Rezoning Transportation Analysis

Petition Number: Zoning Petition #2021-004

General Location Identifier: Tax ID 08117410

Date	Description
02-25-2021	First Review (WB)
03-25-2021	Second Review (WB)

**A100**

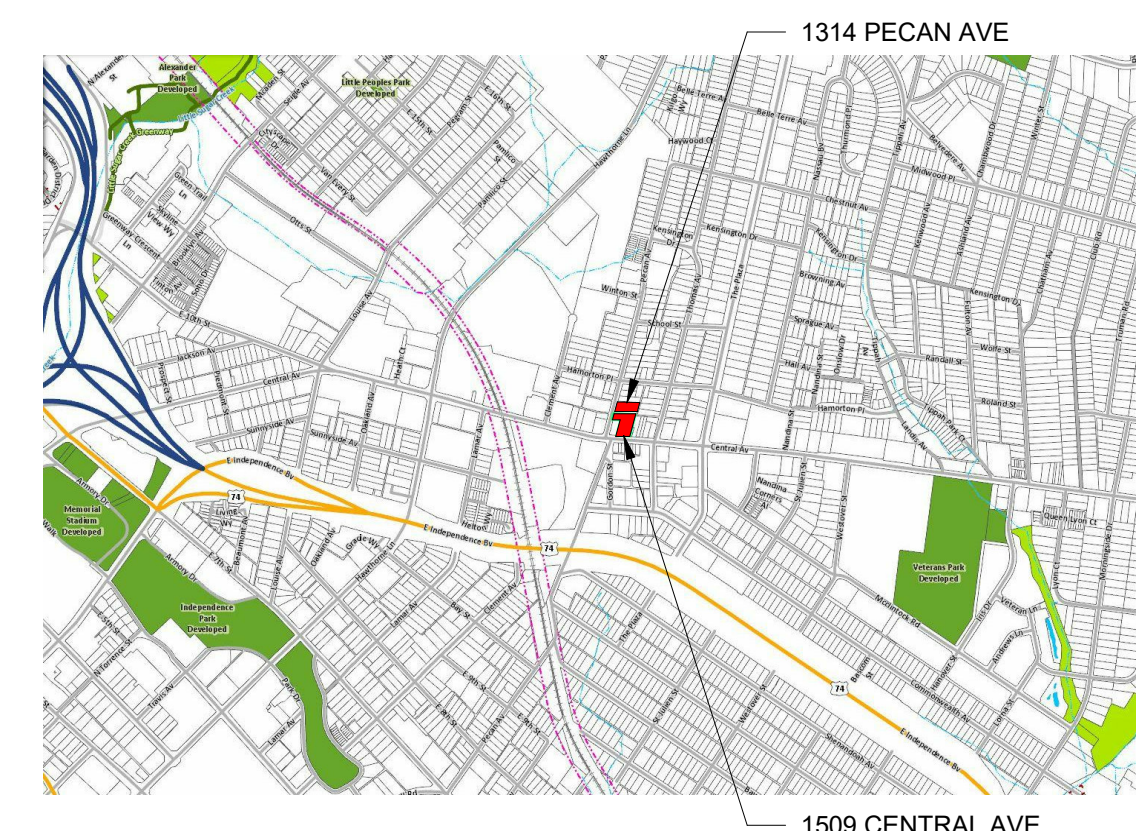
4. Revise site plan and conditional note(s) to commit to dedicating 40' right-of-way from the Central Avenue road centerline. The site plan shall label and dimension the right-of-way from the road centerline.

Revised based on site plan dated 03/15/2021.
